Office of the General Manager

13 December 2023

SUBJECT: BURRENDONG WIND FARM (SSD-8950984) - OBJECTION TO APPLICATION

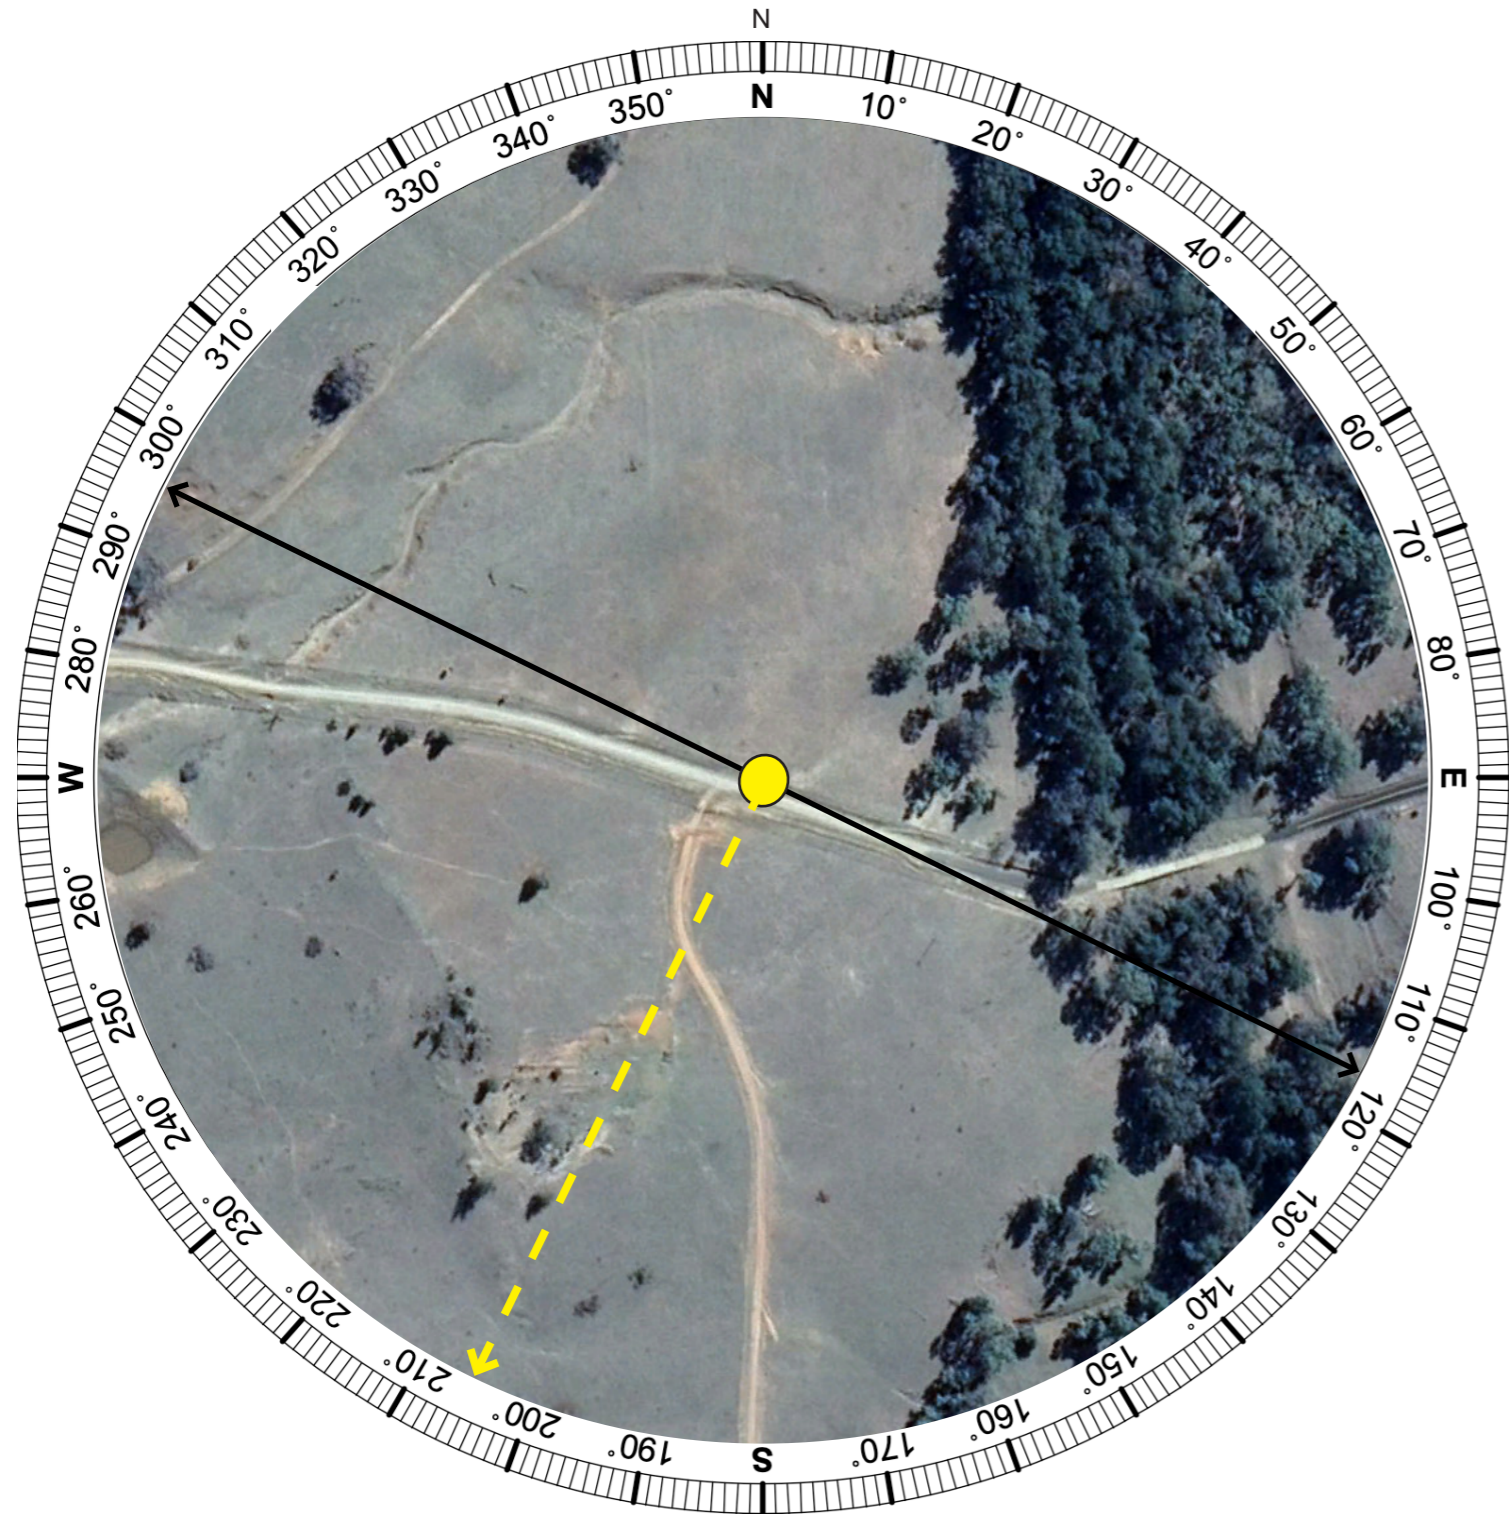
This project is missing from Table 2.1 and importantly missing from the Visual Amenity Assessment. Per Piambong Scoping Report (see page 93 Figure 6-12) the Piambong wind farm is within site distance from this project. It is highlights that some residents will be impacted by 3 wind farms in close proximity – Ungula, Burrendong & Piambong. This has been ignored in this EIS. Council request the Visual amenity is re-done to include this project.

DRAWING TITLE:
**STRATEGIC DESIGN
SWEPT PATH PLAN - OSOM VEHICLE**

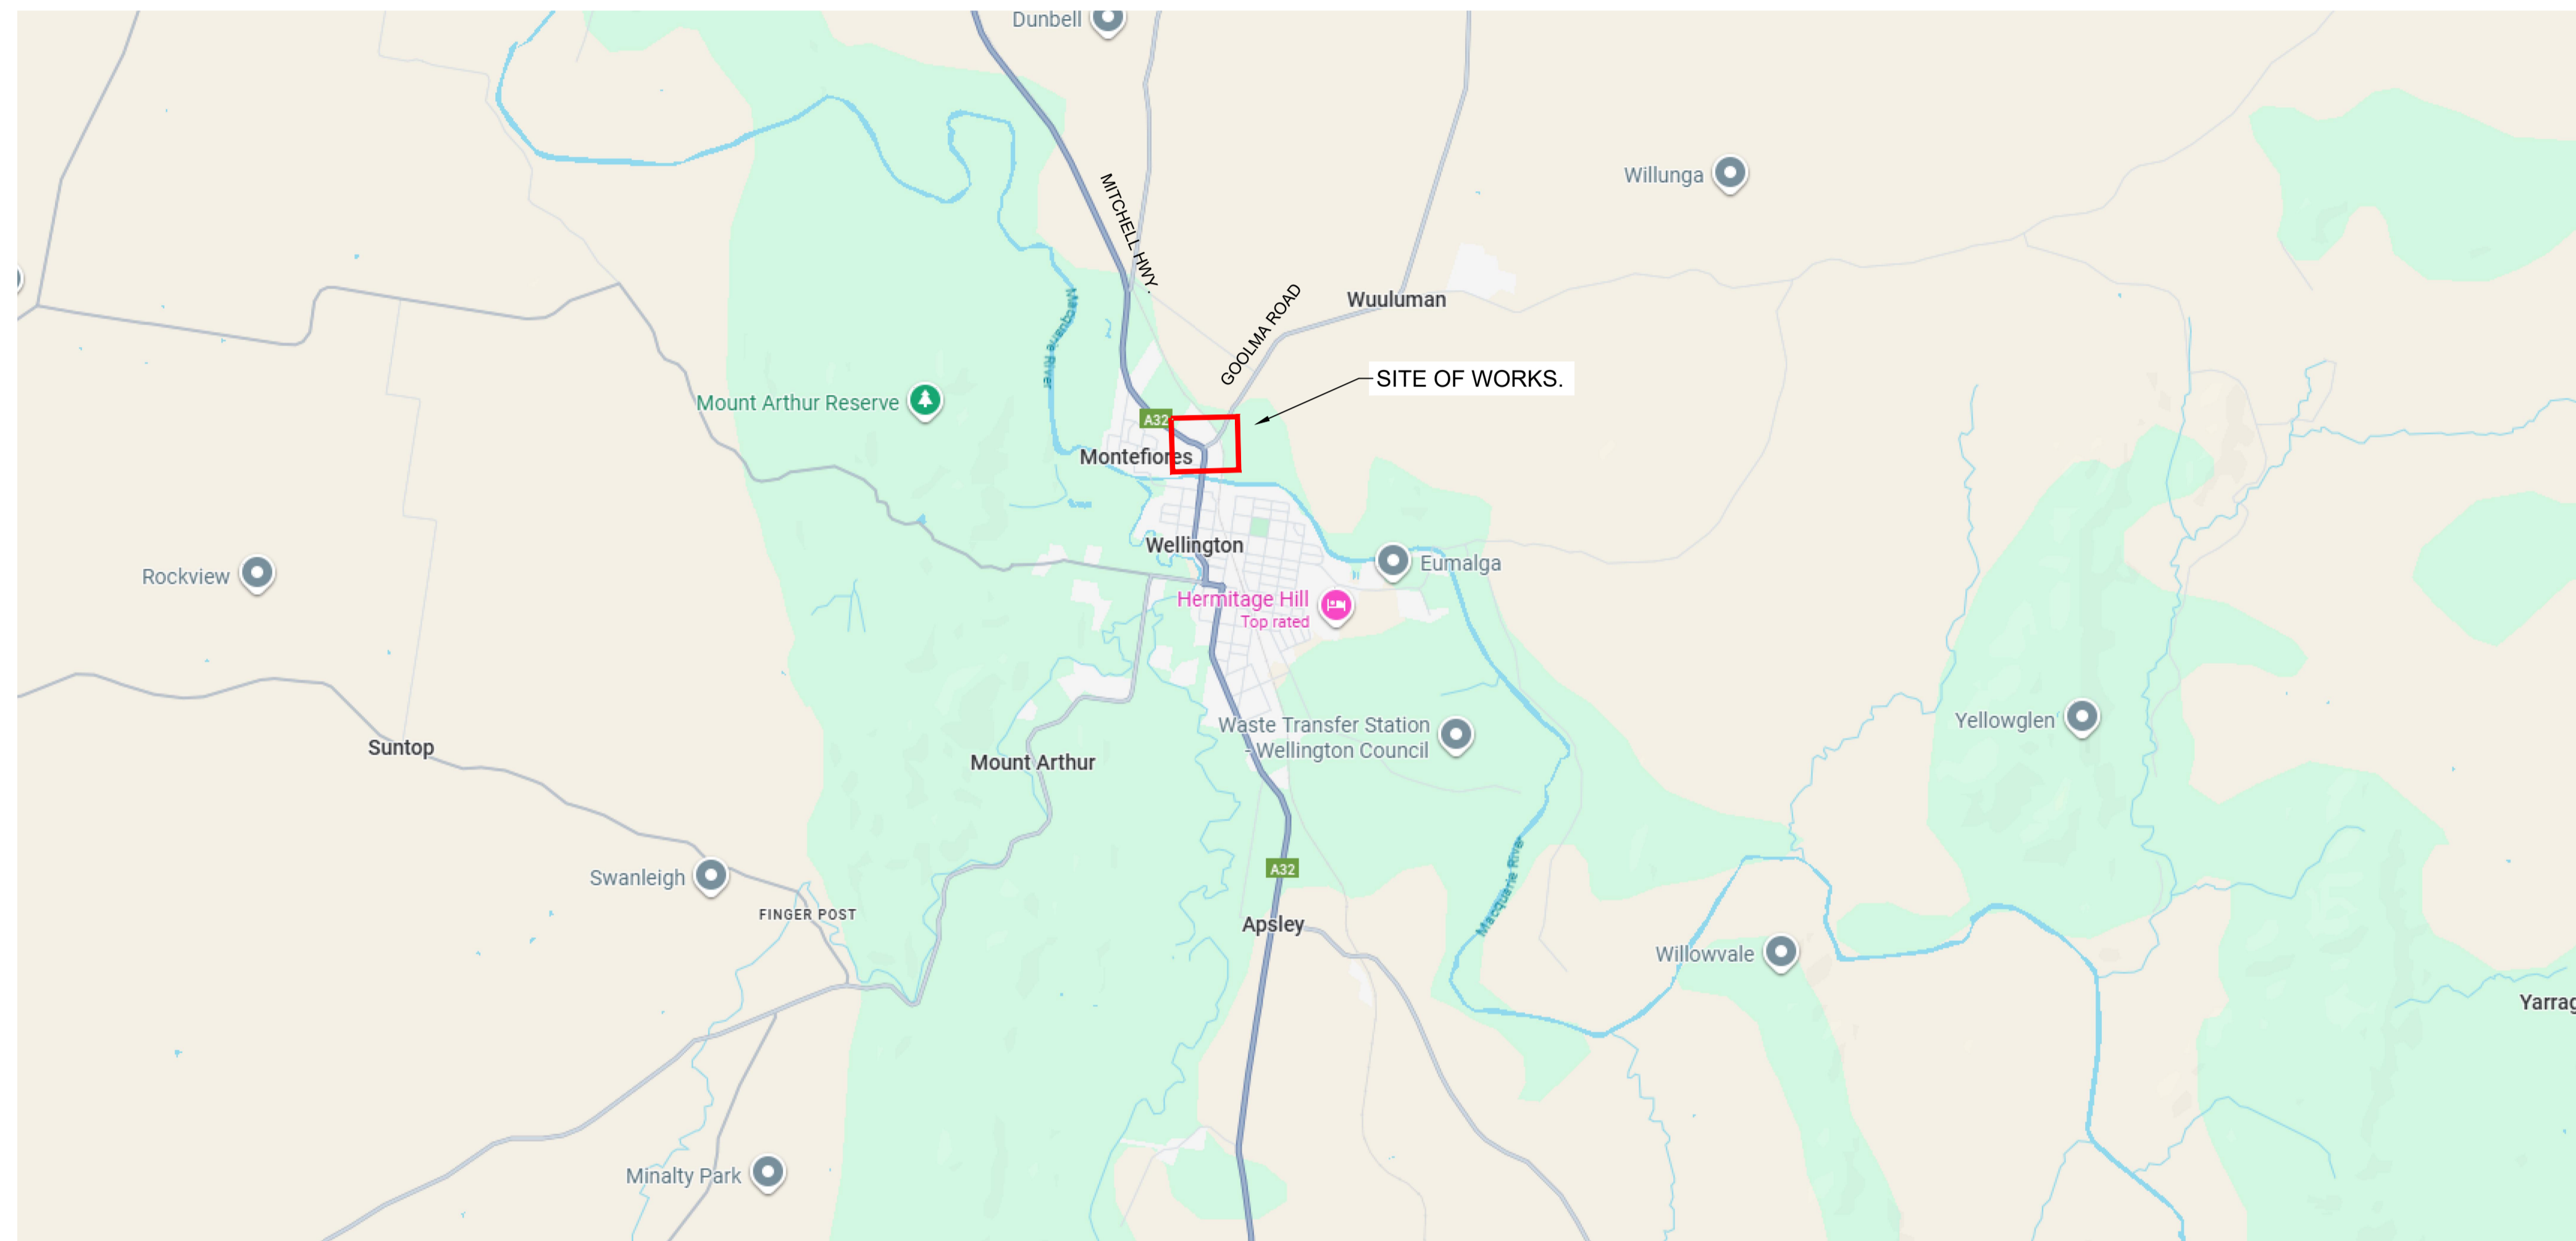
4. Appendix I – Traffic & Transport Assessment table 4.3 provides for intersection upgrades to Goolma Rd/Twelve Mile Rd only. Council requires the applicant to consider cumulative peak traffic volumes through intersections, that is it must include for traffic volumes generated from existing local traffic, other nearby renewable energy projects during working hours and to/from workers camps out of work hours as well as consider the swept path for the largest OSOM (Over Size Over Mass) vehicle to access the roads. To that end

the intersections of Goolma Rd/Twelve Mile Rd, Castlereagh Hwy / Hill End Rd, and Hill End Rd/Yarrabin Rd are to be reassessed.
